TOWN AND COUNTRY PLANNING ACT 1990

Reference:	H11-0515-23	Date of Decision:	16th November 2023
Applicant:	Ms K Streets Holmhurst 24 Wisbech Road Long Sutton Spalding PE12 9AG		
Location:	Holmhurst 24 Wisbech Road Long Sutton Spalding		
Description:	Erection of outbuilding - Retrospective

188-01-DD01

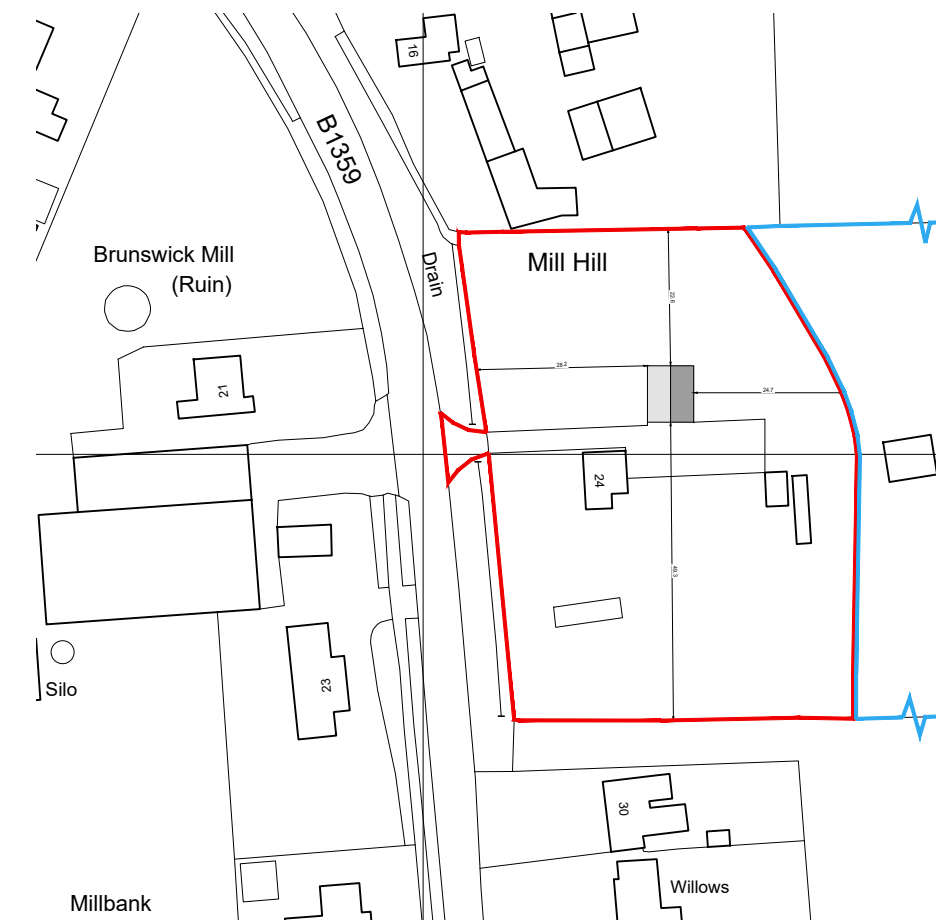
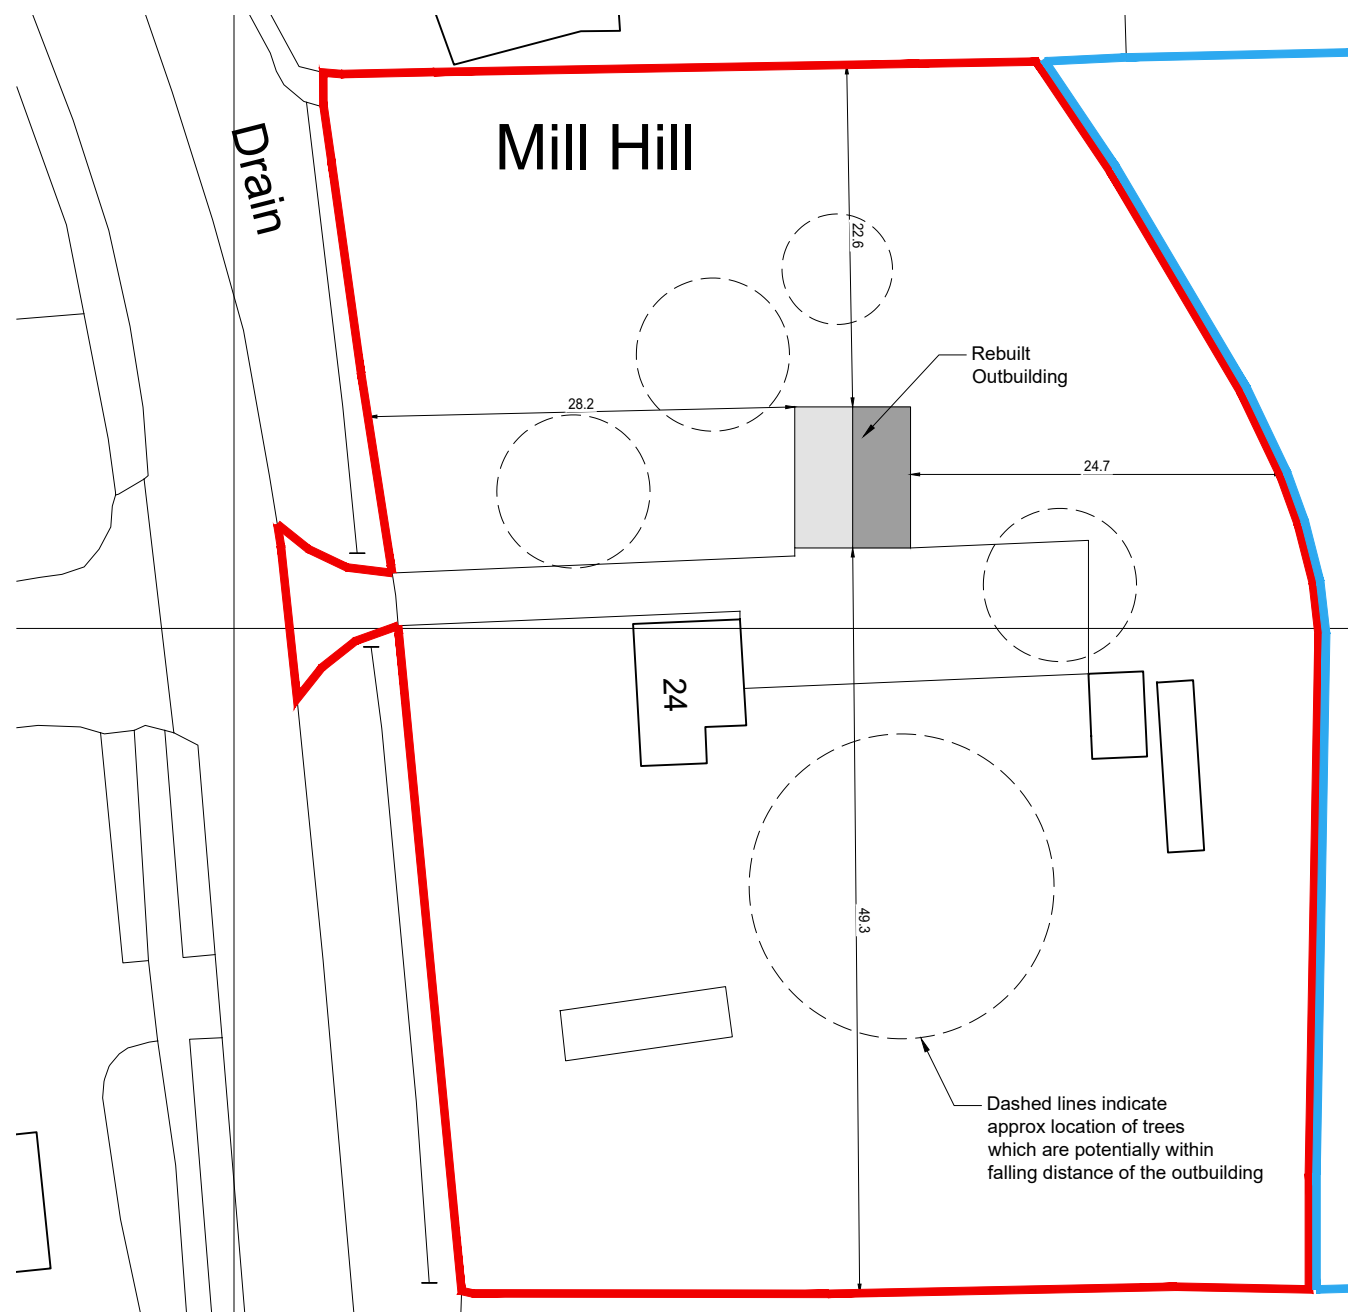
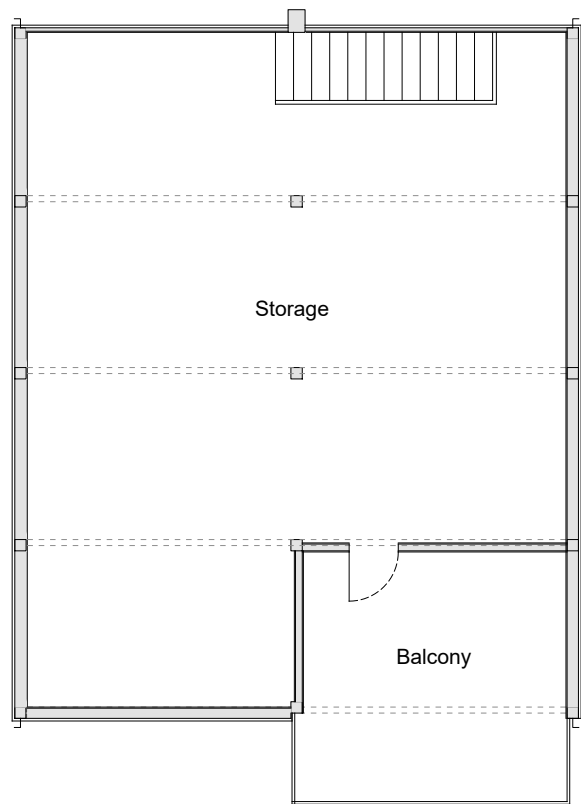
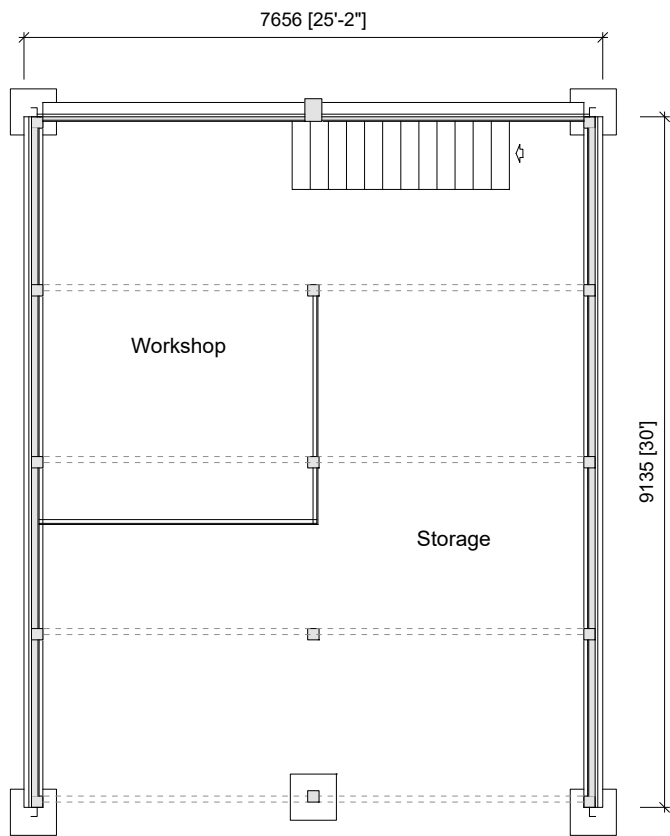
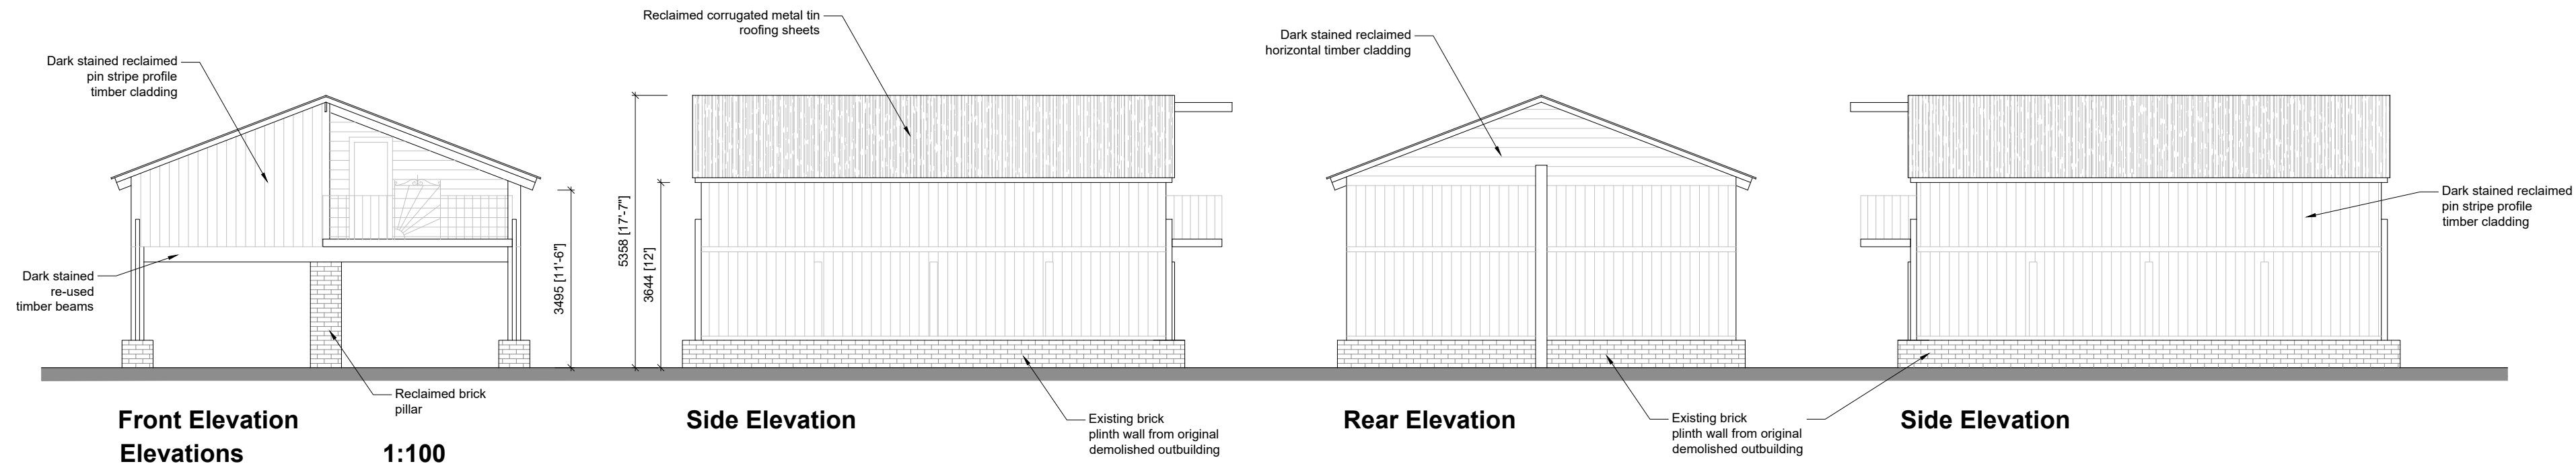
- 1 The newly erected building is far larger in scale than that which it replaces and is of a totally different style, considered inappropriate for a setting within such close visual range of a locally prominent listed building. The visual impact that the proposed structure bears upon the host listed property and the close proximity it is set within, relatively compared to its scale results in highly infringed views of the listed property, particularly from the roadside and wider public realm. Therefore, it appears totally incongruous in the setting of its host, having an unacceptable impact upon the setting of the listed building, failing to either preserve or better reveal its significance and also to respect the wider historic environment in terms of scale, massing, and visual impact upon a locally prominent heritage asset. Therefore, the proposal is considered to be in breach of Policies 2, 3 and 29 of the South East Lincolnshire Local Plan (2019).
